EPC STORMWATER REVIEW COMMENTS  
IN ORANGE BOXES WITH BLACK TEXT

# SADDLEHORN RANCH - FILING 4

## GRADING AND EROSION CONTROL PLANS

GRADING & EROSION CONTROL PLANS

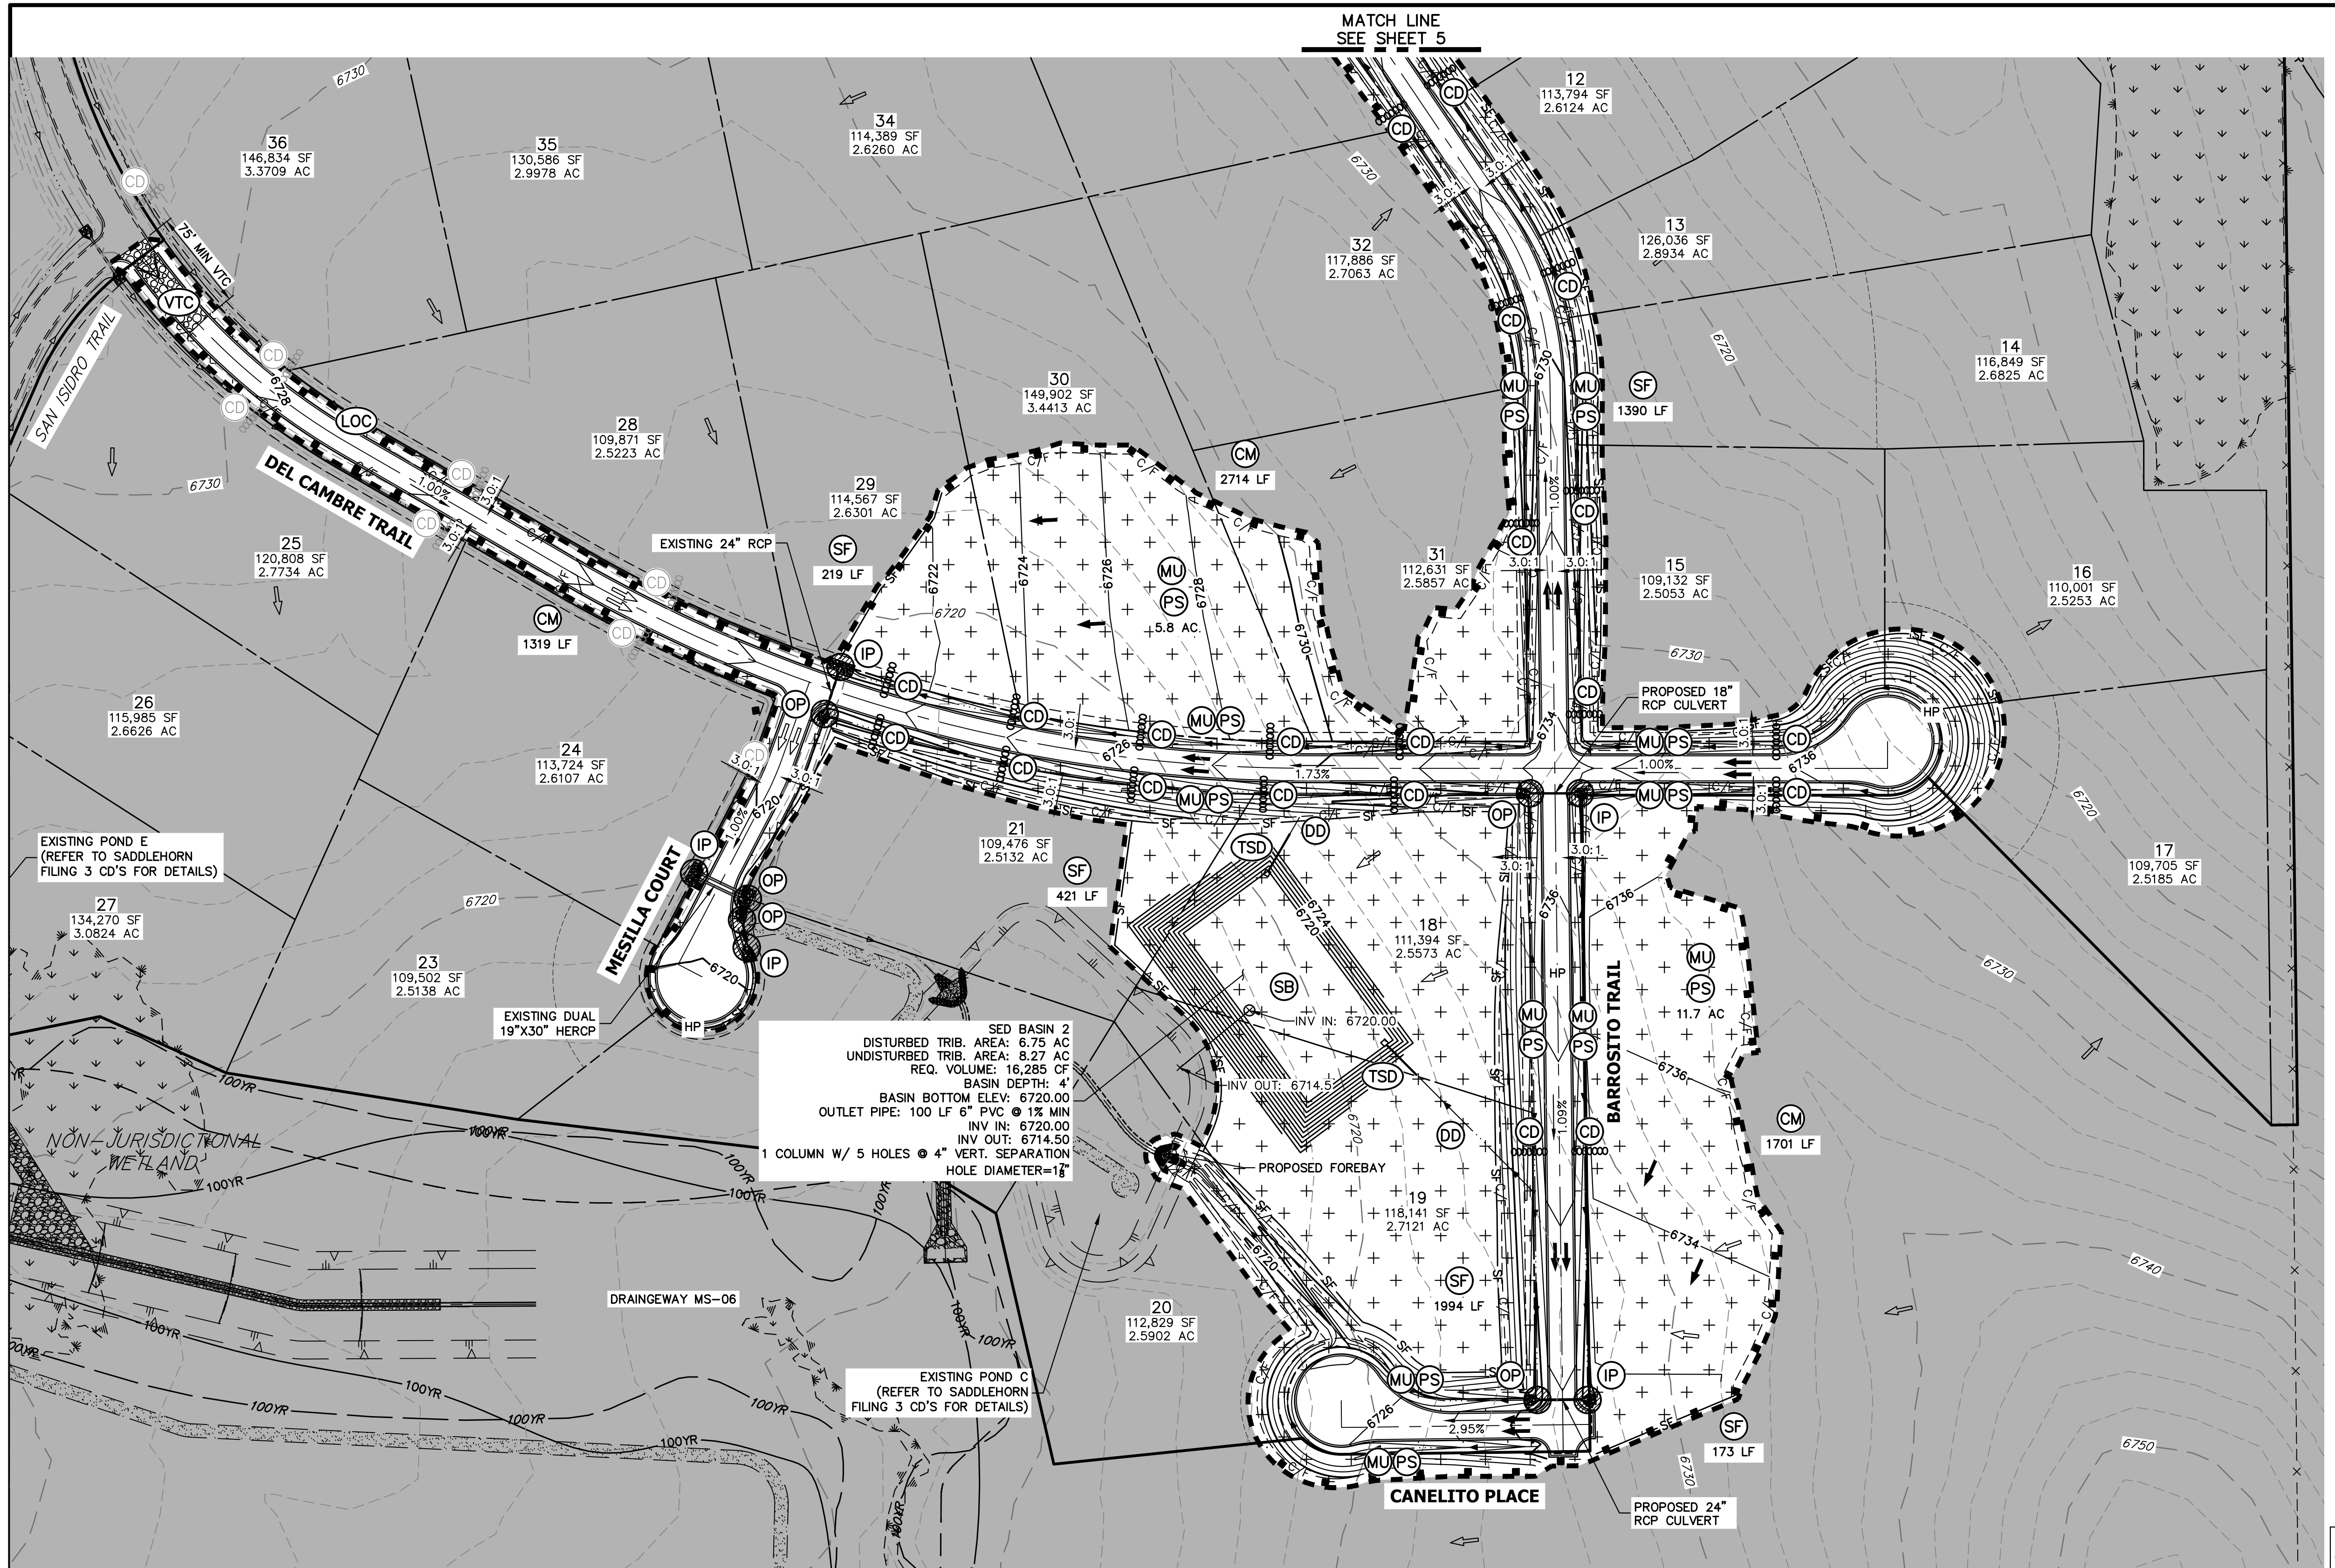
Provide Site specific detail on how the OP BMP will work with the pond outlet structure.

Is the outfall existing or proposed? Please label.

Verify RRB's and ECB's are proposed and if not remove from legend. I did not locate those BMP's on the plans.

GEC Checklist Item b - label all property parcel numbers
